**For Planning Permission to carry out engineering operations
to form a hard surface and pond and to use the site for the
display of motor vehicles
Maple Garage, Aldbrough Road, Flinton, Hull, East Yorkshire,
HU11 4NA**

Supporting Documentation and Checklist

Application No 24/00824/PLF

proposed site plan

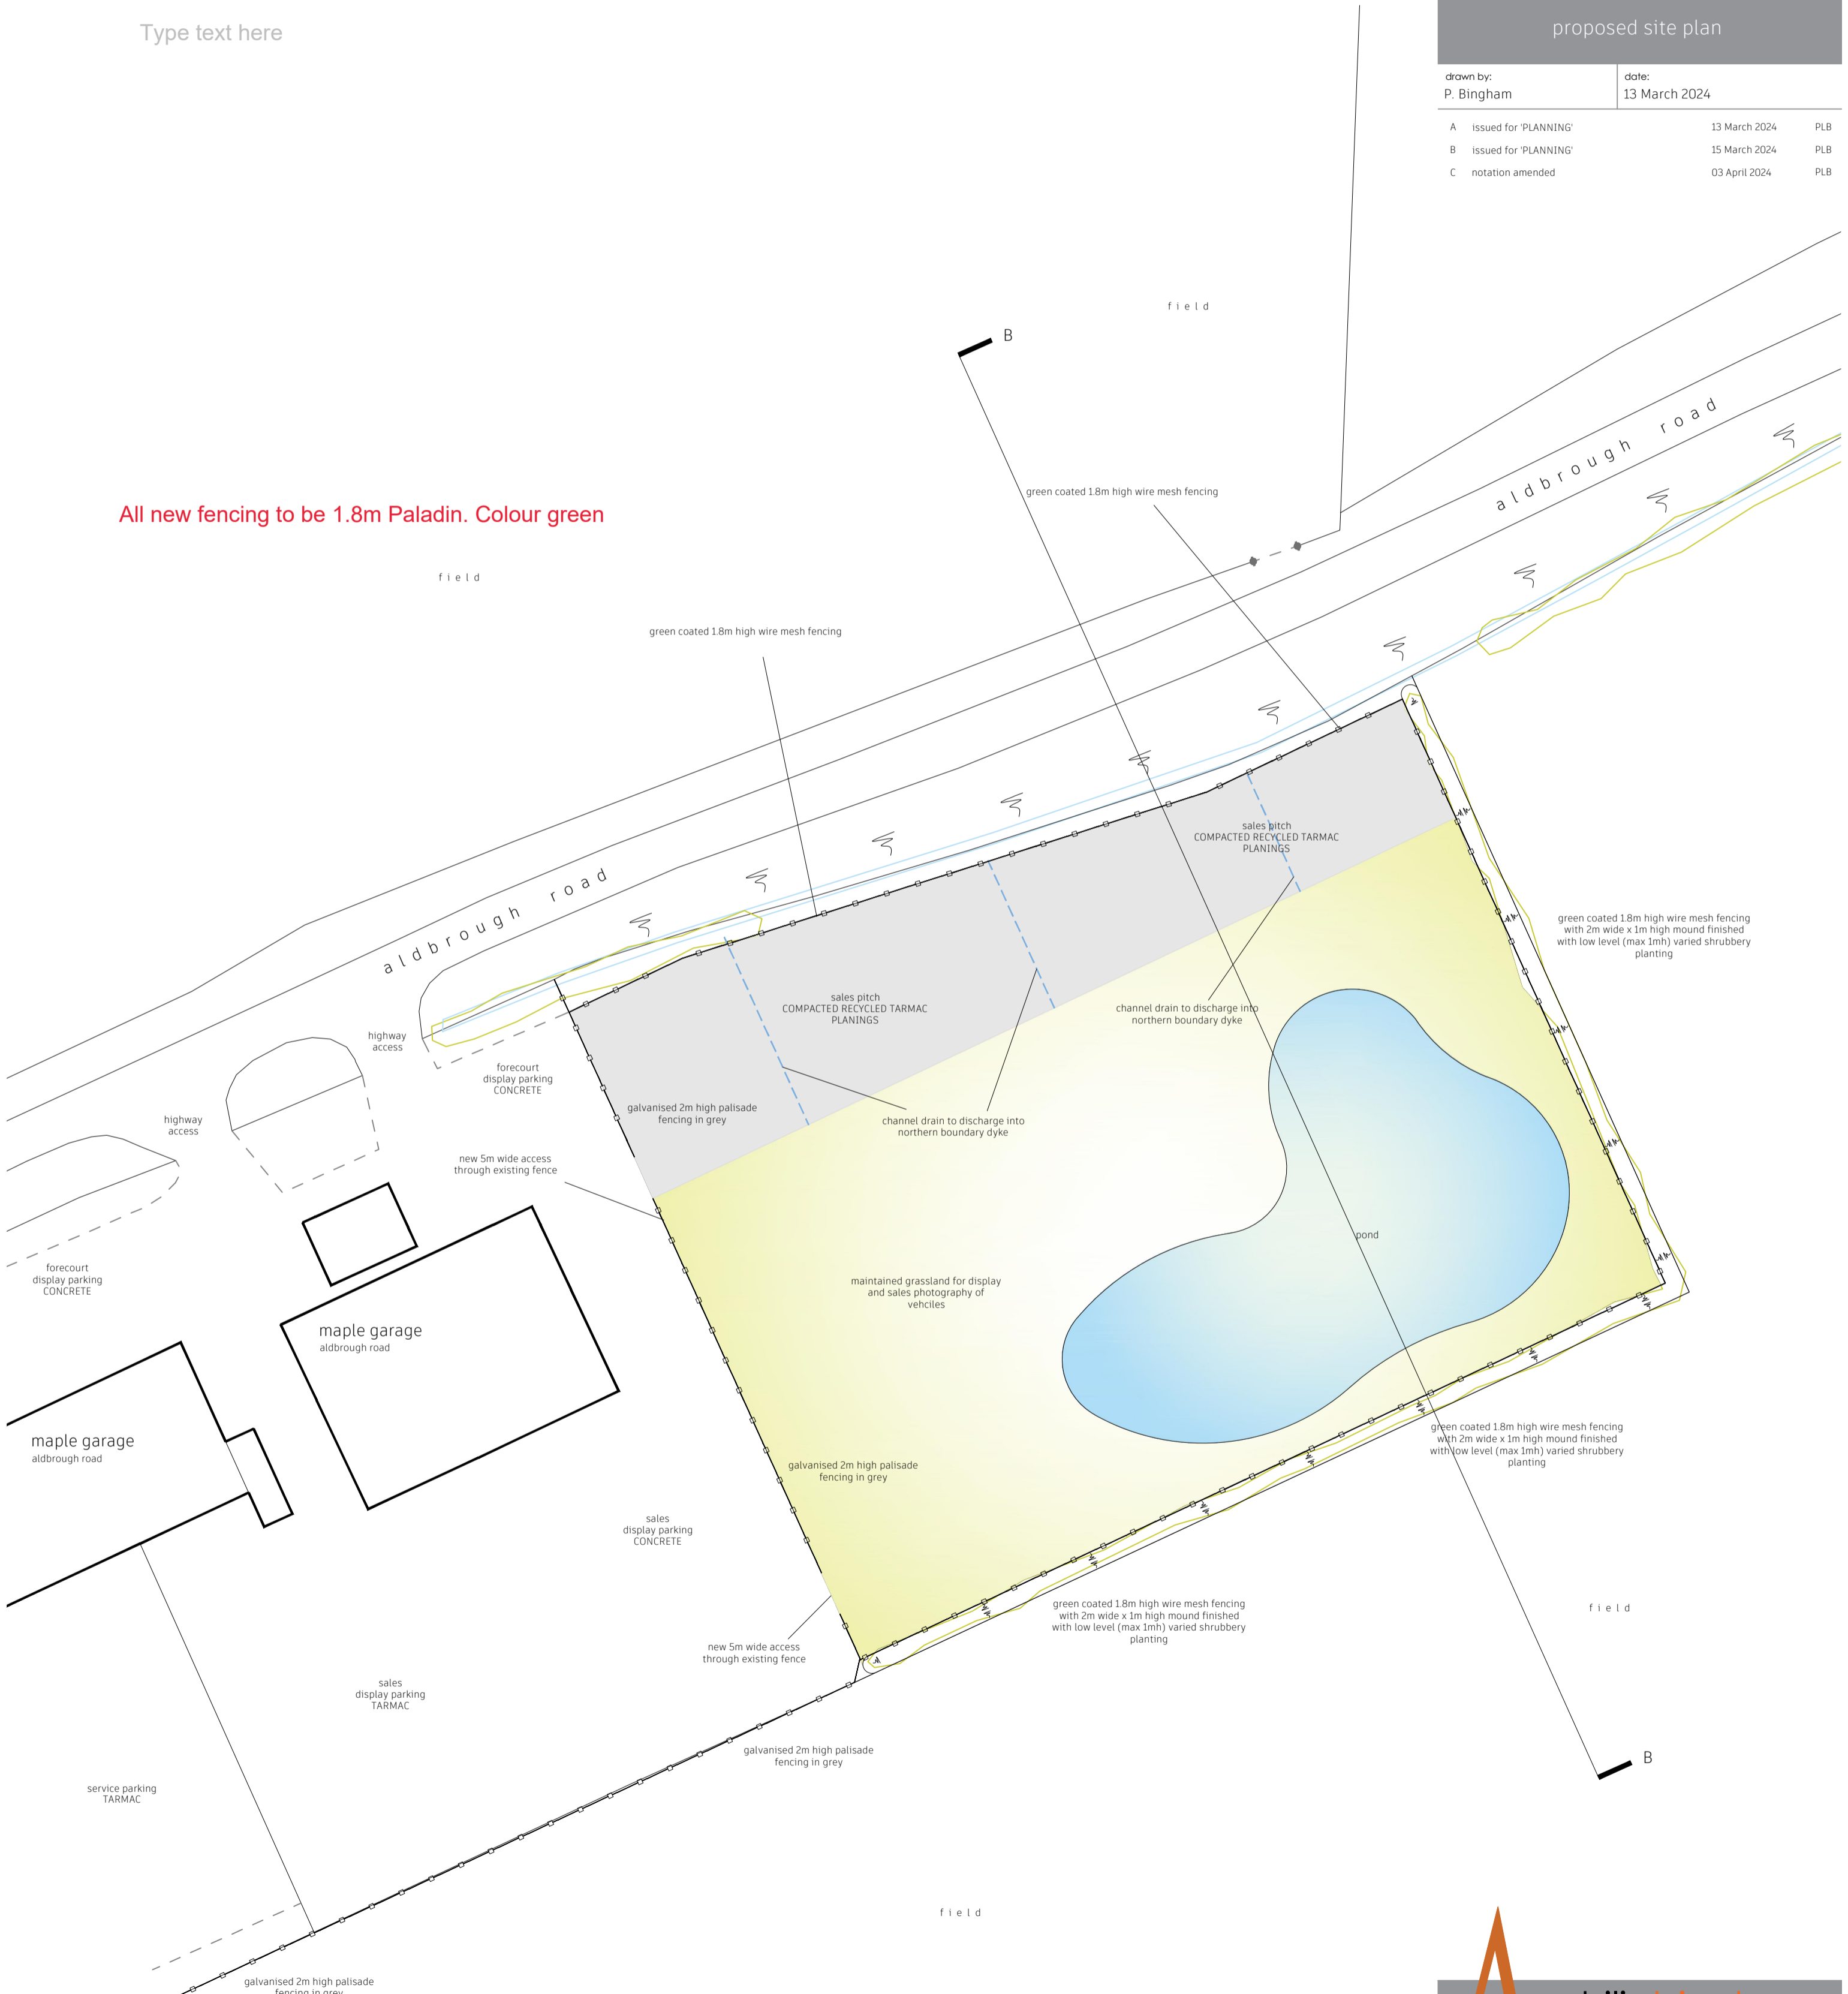
Reason	Response
The proposed site plan indicates new fencing, any new gates or other types of boundary treatments such as fencing over 1m high, you are required to provide an elevation drawing of these. The drawings should be drawn to a scale of 1:100 or 1:50 with scale bar.	It is not necessary to provide drawings of a fence provided that the fence is adequately described. For example, if a drawing specifies a 2m high close boarded fence, that is sufficient. In this case, the fencing proposed is 1.8m high paladin in a green finish.
The location plan shows a blue line part thereof, which appears to indicate that the applicant owns the land to the south and east of Maple Garage Sproatley Ltd. However, checking the application form, Certificate B has been served on a Mr Knapton of Moor Farm, therefore it appears that Maple Garage Sproatley Ltd do not own all of the land or part thereof shown in blue. Please amend the blue line on the location plan accordingly and return as soon as possible.	The applicants own the red and blue land. Mr Knapton is an agricultural tenant. He has been served with notice. The plan and Certificate are both correct and in this respect the application is valid.
